Maine Medical Center
 Visitor Garage Expansion
 Existing Building Code Report
 September 28, 2017

DRAFT FOR CLIENT REVIEW

**CONDITIONALLY
 APPROVED**

City of Portland

6 PERCENT OPENING SUMMARY  
 SCALE: NONE

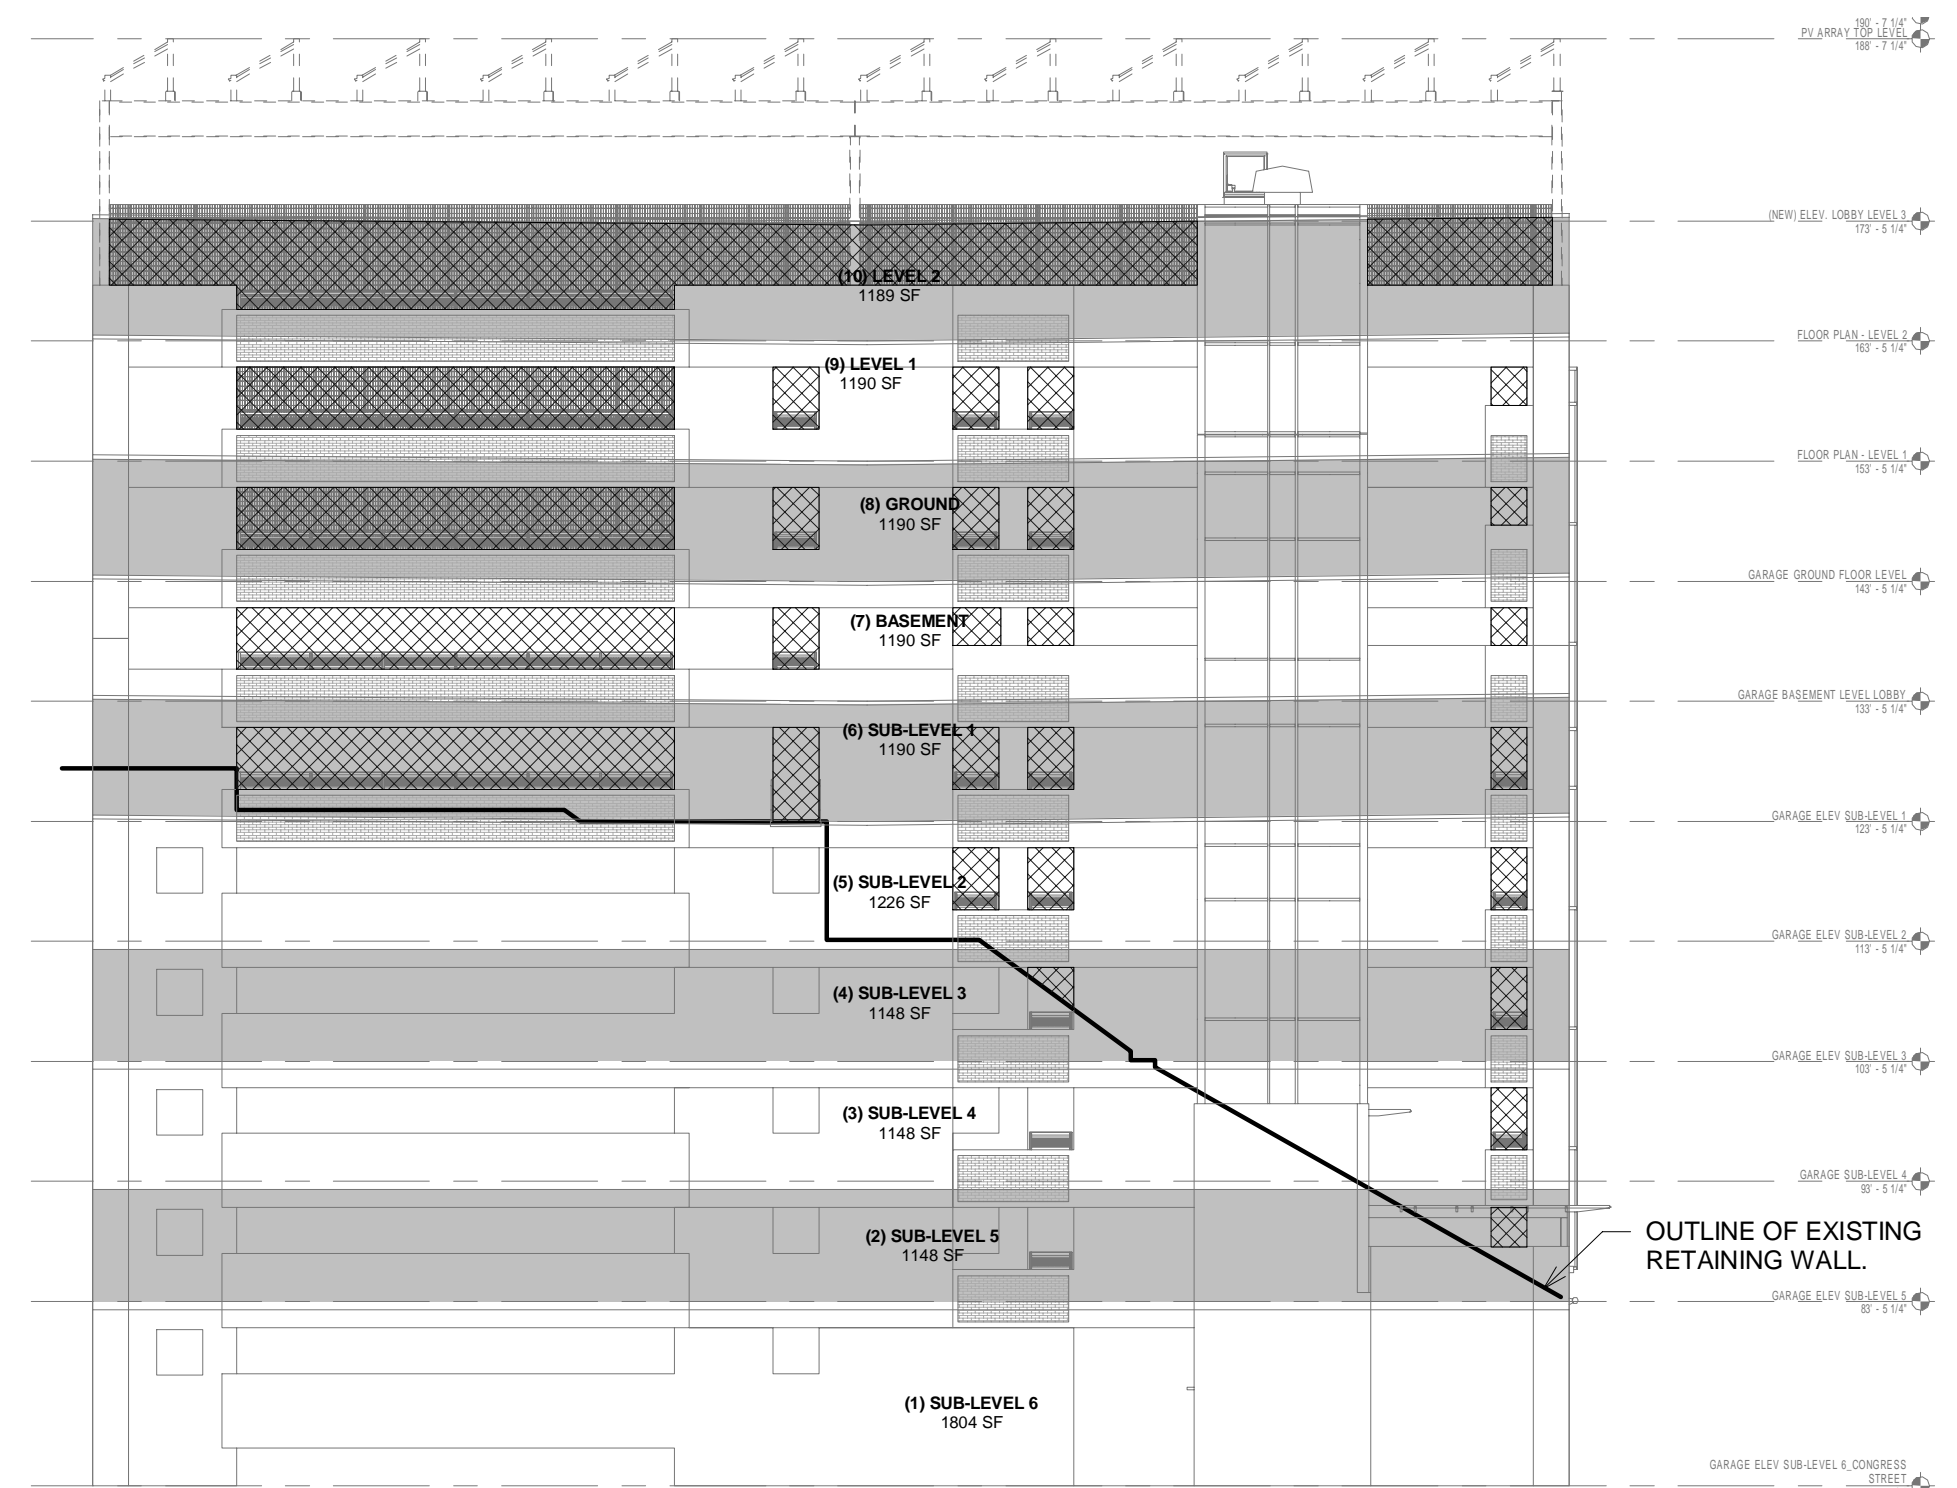
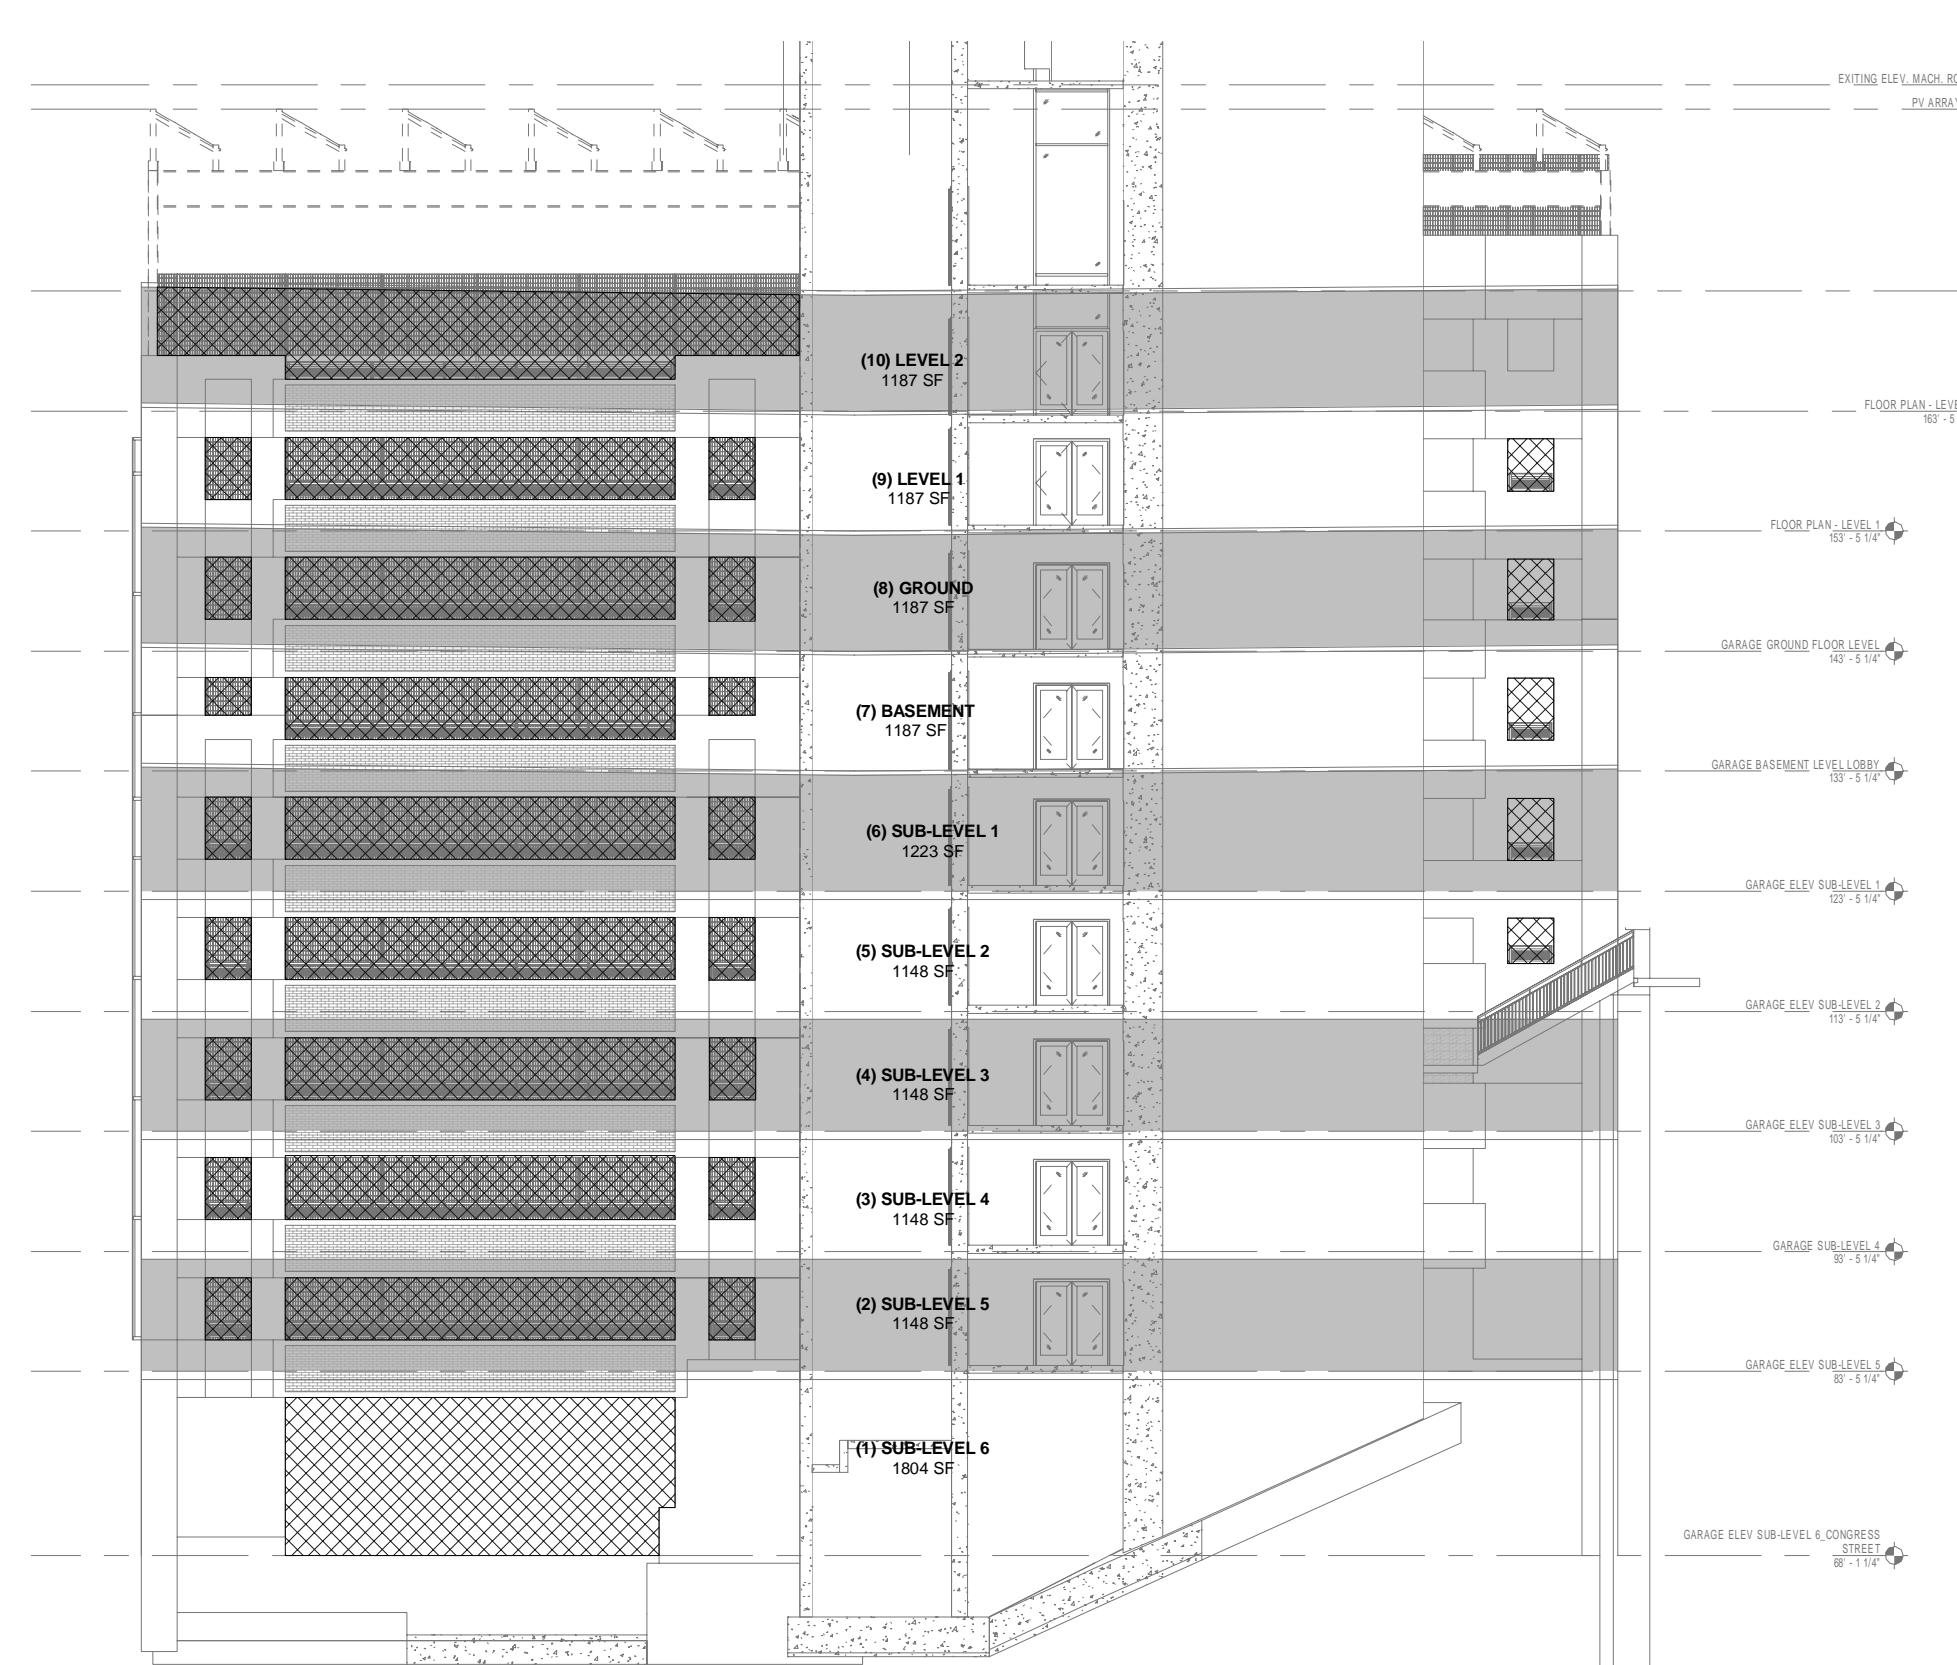
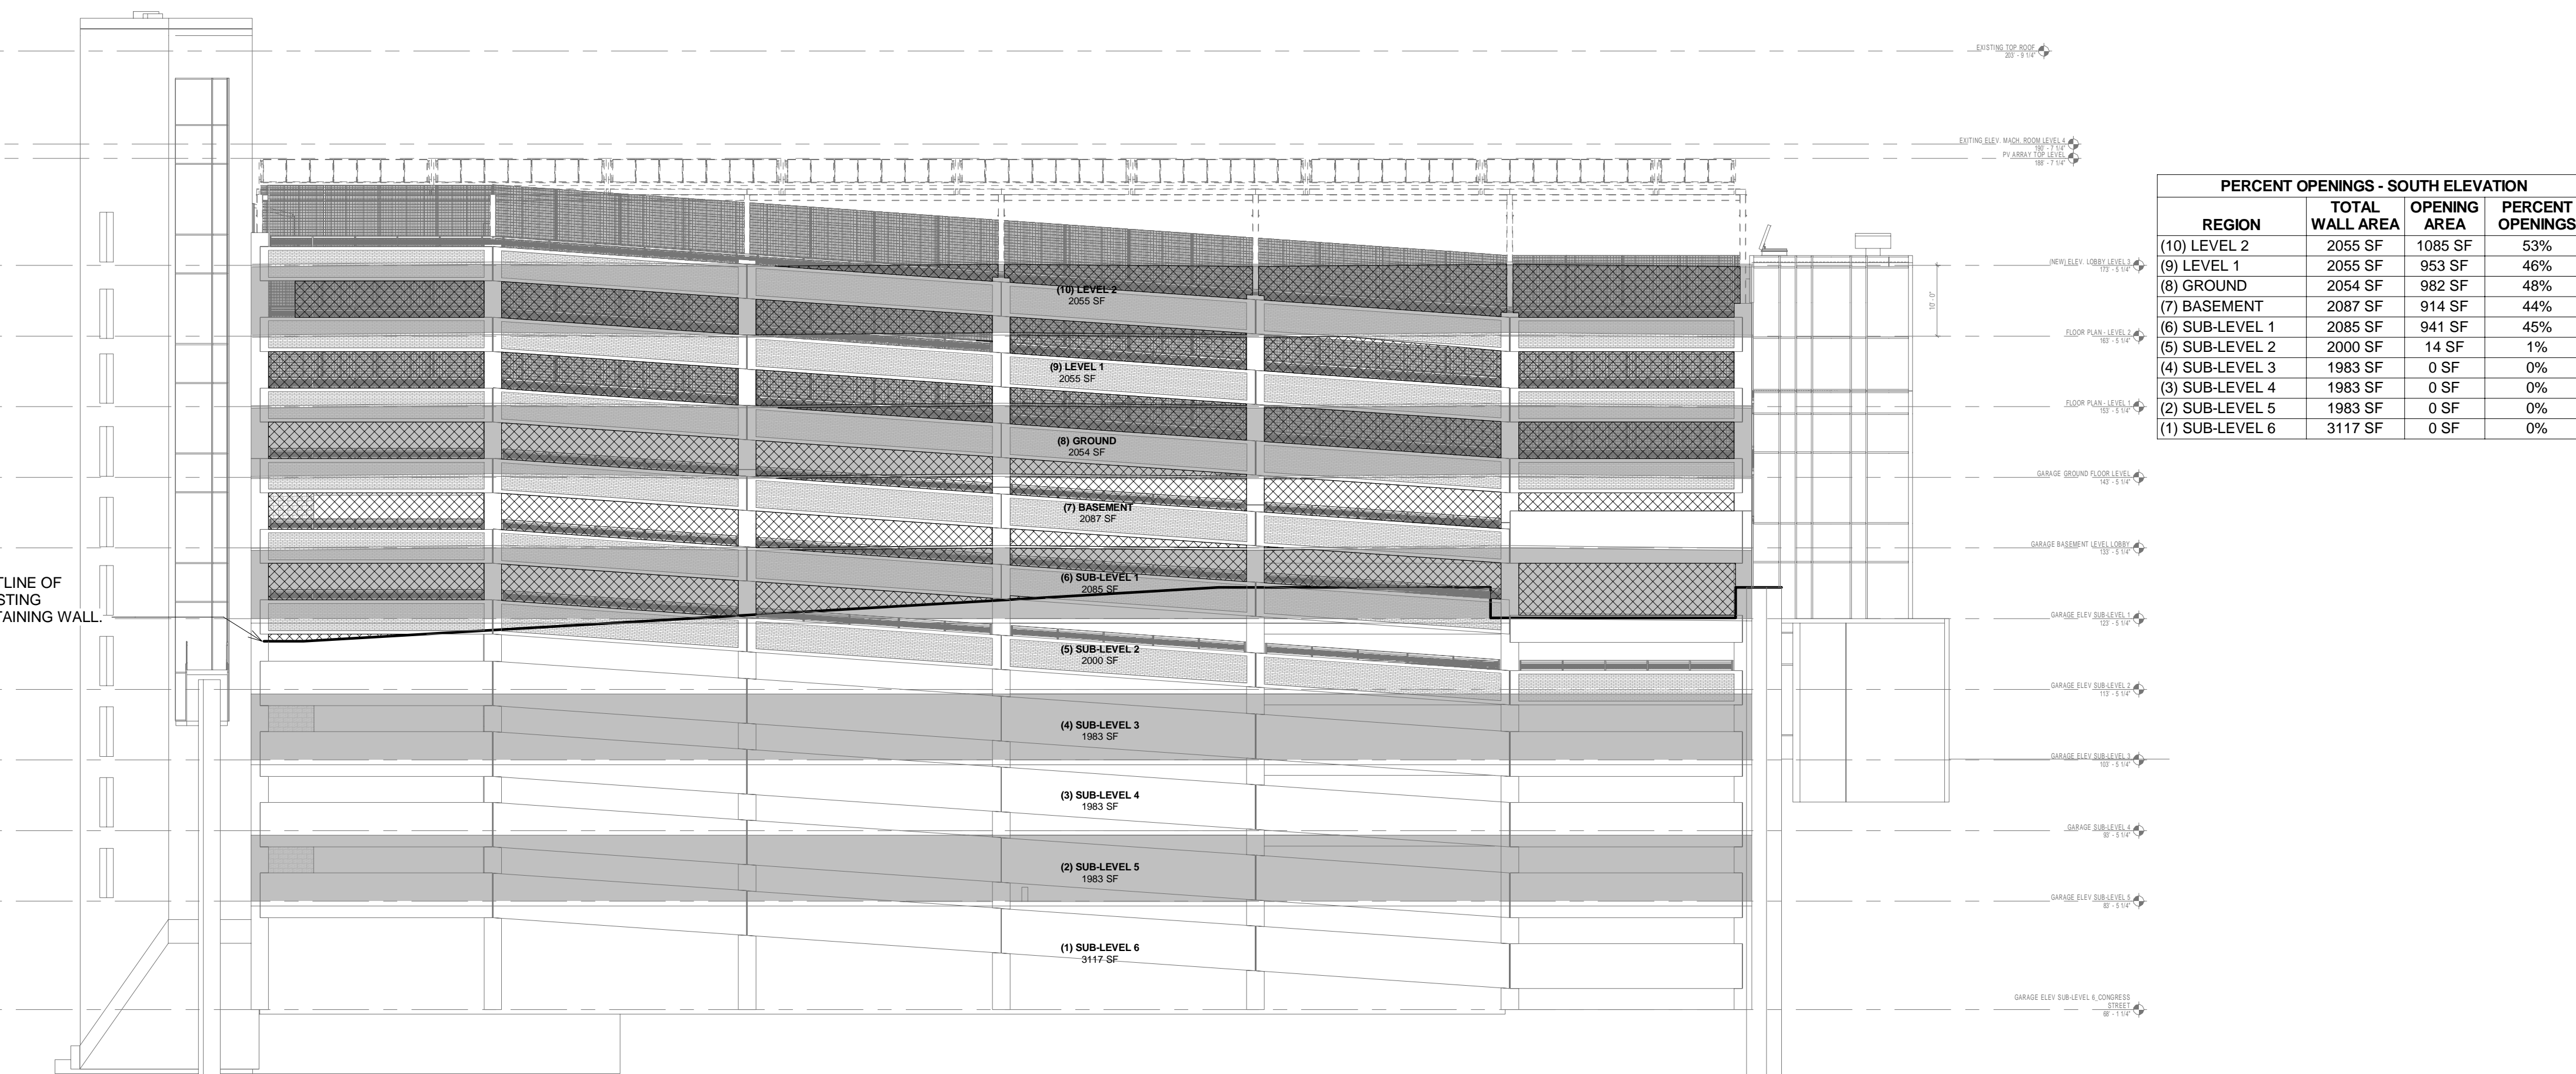
There is an existing retaining wall adjacent to the south and east sides of the building. The retaining wall is approximately 1 foot from the exterior wall of the existing parking garage. This wall therefore obstructs some exterior openings on the south and east sides of the existing garage. As a result, Sub-Level 6 and Sub-Level 5 do not meet the 20% openness requirement of IBC 406.5.2. However, all levels of the garage meet

The existing garage openings are an existing nonconforming condition per IBC provisions, but the openings comply with the openness criteria of NFPA 101. The proposed addition does not extend the nonconformity since the openings in the existing portion of the garage and the location of the existing retaining wall will not be altered as part of the proposed renovations. Therefore, the existing garage will continue to be treated as an open parking garage since it was originally approved and constructed as such. The three new tiers of the garage will comply with the openness criteria of both the IBC and NFPA 101. Therefore the work is in compliance with IEBC 1101.2 and NFPA 101 Section 43.8.1.2. See sheet G02-01 for further details.
